**Heyford Lodge, Heyford Road, Middleton Stoney,  
OX25 4AL**

**23/01646/F**

**Proposal:** Single and two storey extensions and internal modifications to existing dwelling

Rev	
Project Heyford Lodge Park Farm Middleton Stoney	
Client J H Norman & Sons	
Drawing Proposed All Elevations	
Drawing No: 02/2023/05	
Issued for: Planning	
Date Mch 2023	Drawn by MCH
Scale(s) at A3size 1:100@A3

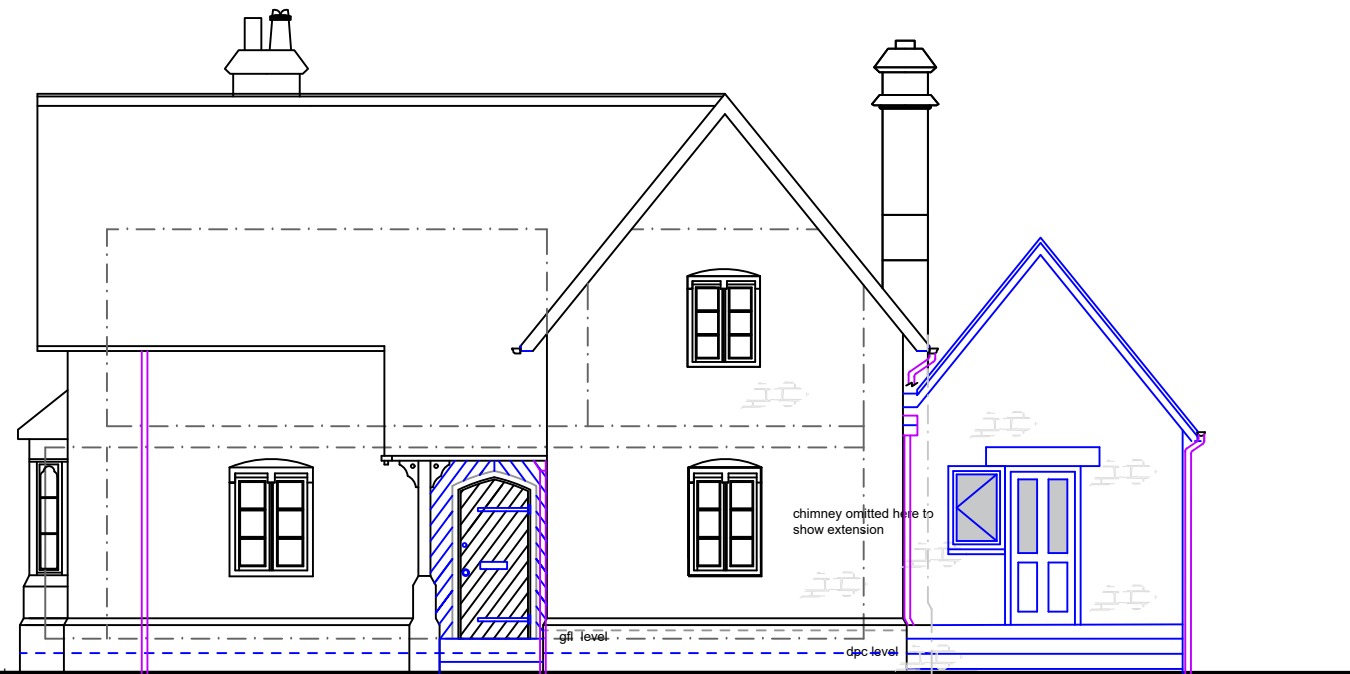
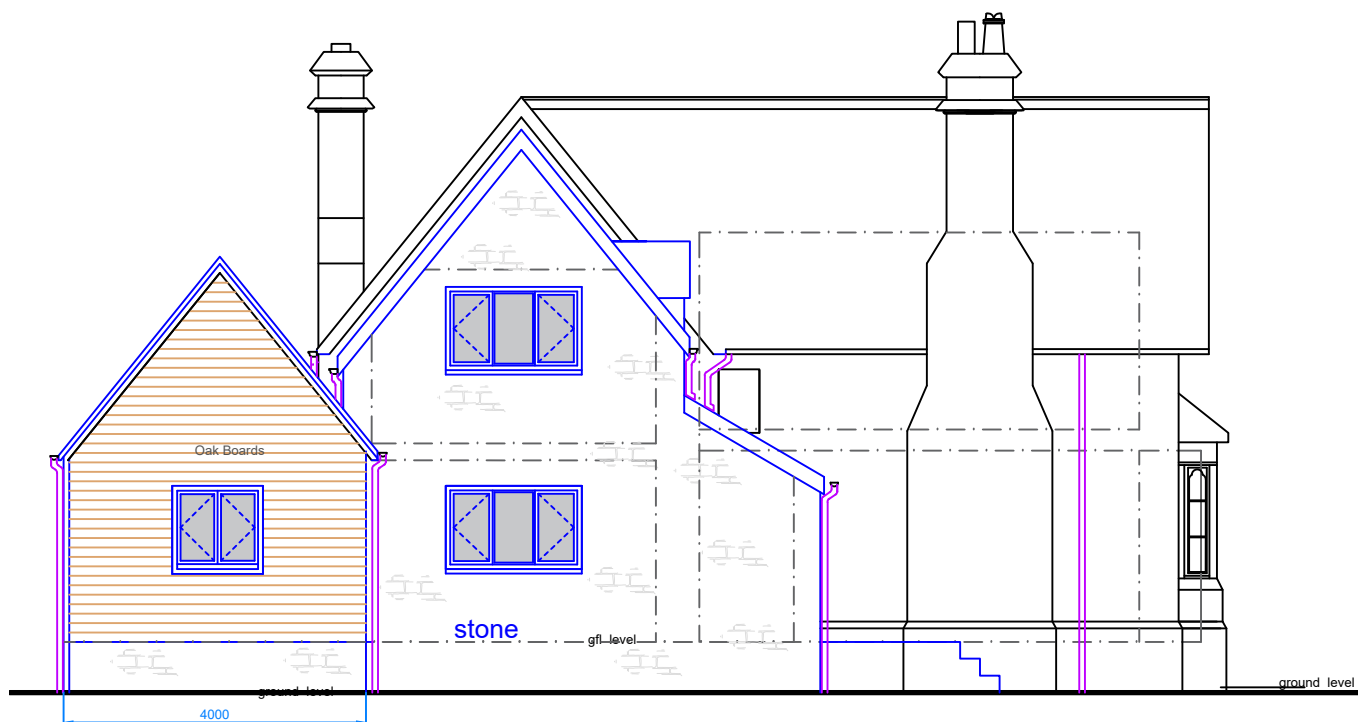
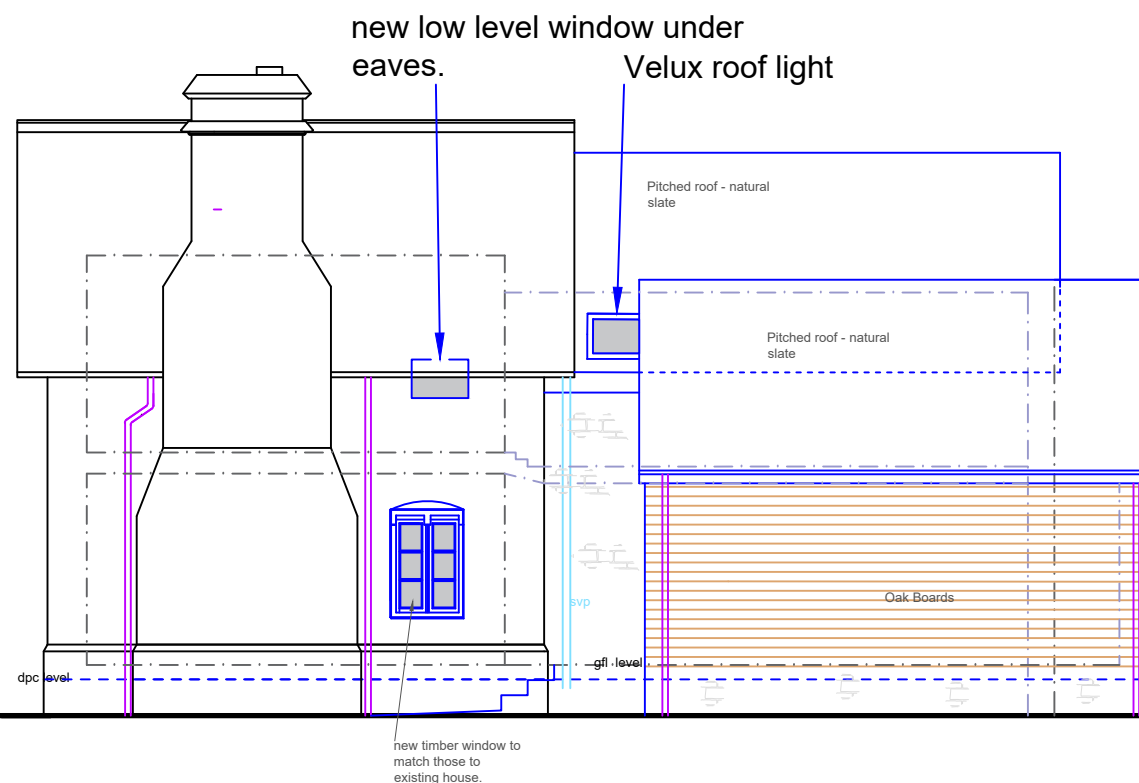
The application proposes a substantial extension to the existing dwelling, with a footprint 153% larger than the footprint of the existing dwelling. The single storey, timber clad, pitched roof element of the extension would also serve to stagger the northern elevation and bring it closer to the road. The use of timber cladding as a construction material is not generally supported in the District upon residential extensions, as indicated in the Residential Design Guide.

Whilst the roof ridge height of the proposed two storey extension would be set lower than that of the existing dwelling, it would constitute a bulky addition that would conceal the majority of the visually prominent western facing elevation of the dwelling, which is at present a neat and attractive gable with characteristic eaves detailing. The chimney features would also be partially obscured from view. The design of the lean-to element of the two-storey extension would appear rather contrived with a section of roof cut away to avoid concealing the landing window, although I acknowledge that this would not be visible from the public domain.

Eaves level dormer windows are proposed within the southern facing roof slope of the two-storey extension, which are not features of the existing building, and these, together with an incoherent assortment of openings that do not resemble the appearance of the existing openings, would all result in a fussy and discordant appearance.

It is considered that the extensions, by virtue of their size, design, siting and choice of construction material, would appear as bulky, overly prominent, unsympathetic and discordant additions to the dwelling that would draw undue attention to themselves, detracting from the visual amenities of the area and resulting in less than substantial harm to the historic significance of this heritage asset and the setting of the Middleton Park Grade II listed Registered Park and Garden. With no public benefits to outweigh the harm identified, the proposal is considered to be contrary to Policies ESD 13 and ESD 15 of the CLP 2015, saved Policies C28 and C30 of the CLP 1996, and Government guidance contained within the NPPF.
